**From:** Cruse & Associates <cruseandassoc@kvalley.com>  
**Sent:** Friday, February 22, 2013 9:14 AM  
**To:** Jeff Watson; Holly Duncan  
**Cc:** Cathy Busha Law Offices; Paul Dempsey  
**Subject:** Re: BL-11-00024 Otte  
**Attachments:** Otte.pdf

**From:** [Jeff Watson](#)  
**Sent:** Wednesday, October 05, 2011 8:15 AM  
**To:** [Chris Cruse \(cruseandassoc@kvalley.com\)](mailto:Chris Cruse (cruseandassoc@kvalley.com))  
**Subject:** BL-11-00024 Otte

**From:** Jeff Watson  
**Sent:** Tuesday, October 04, 2011 11:47 AM  
**To:** Christina Wollman; Brenda Larsen; Jan Ollivier; Holly Duncan  
**Subject:** BL-11-00024 Otte

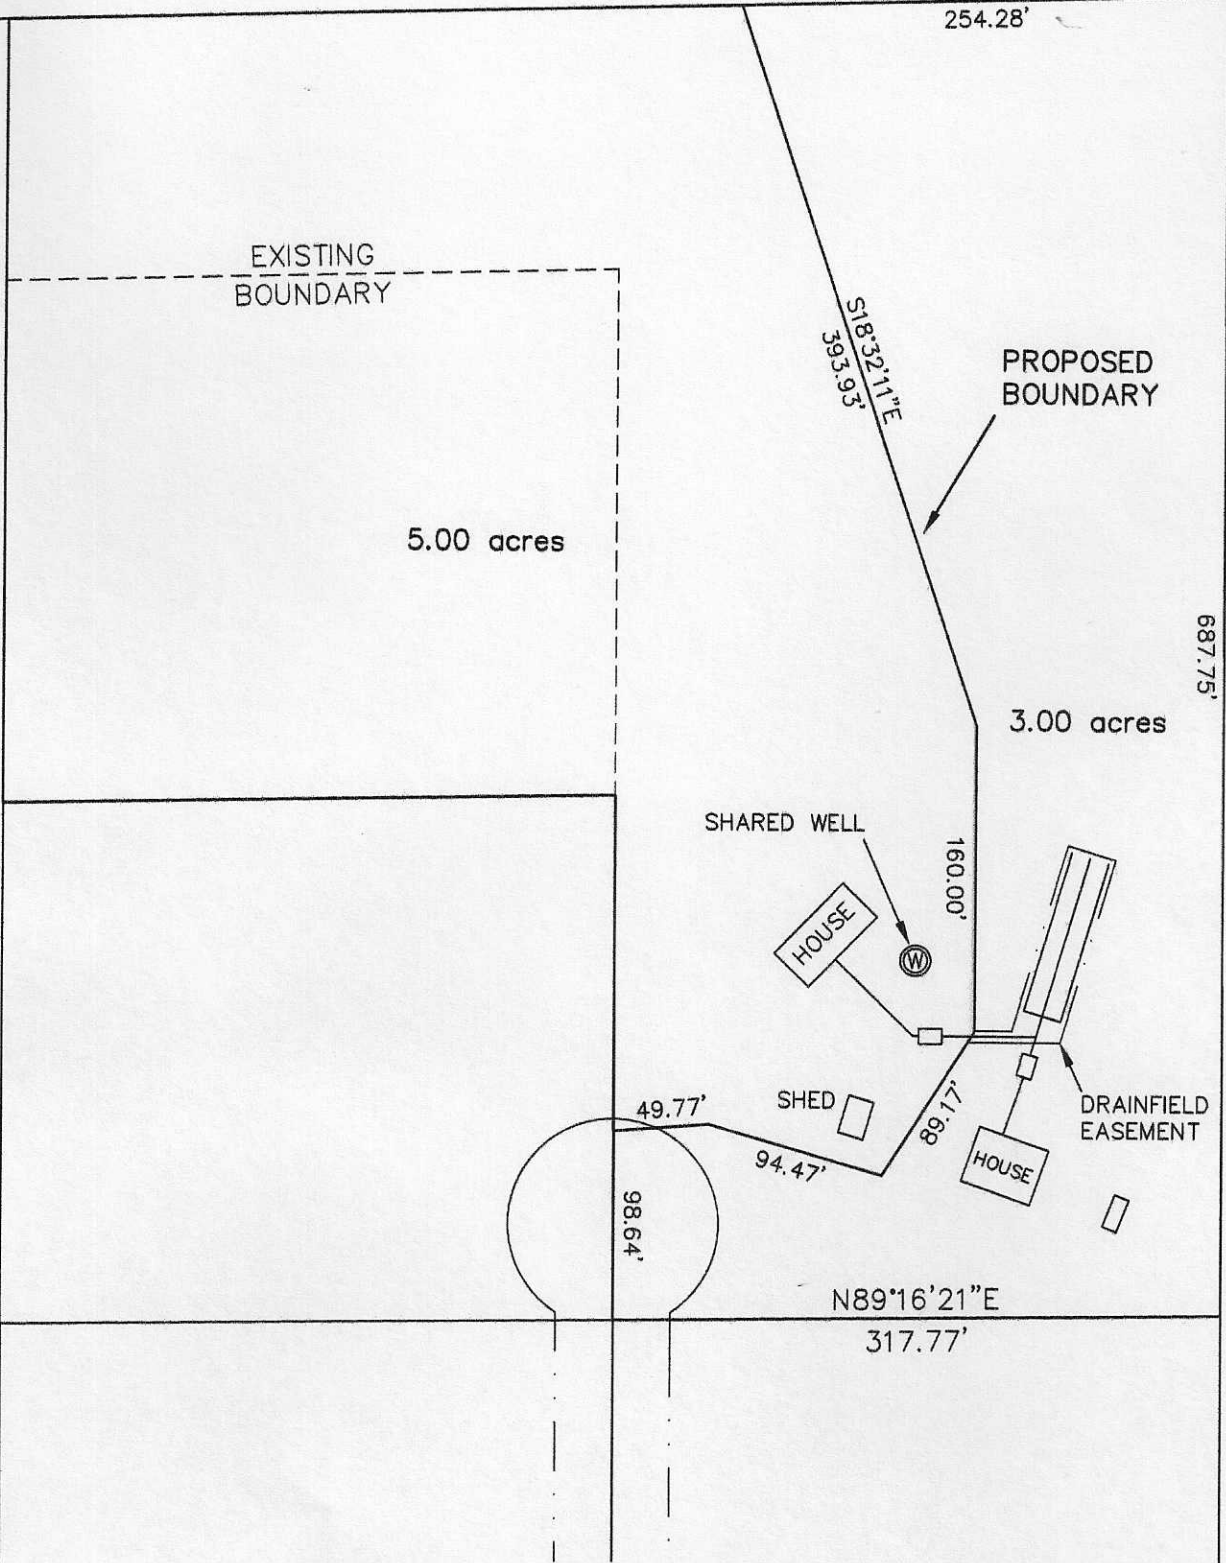
I also have questions on this one. It appears that the proposed project will have a lot line going through the area where the house, well site and drainfield might be. I need a better site plan showing the location of the well and on-site sewage system in relation to the proposed lot line. Can the applicant provide this?

This took a little while but the attached exhibit shows the existing utilities and where both parties would like the revised boundary to end up. Currently there is one well and one drain field that serves both residences. They have agreed to share these utilities and can record the necessary easements and shared well agreements once they have received the conditions for final approval. Please review and contact me back with any questions or concerns.
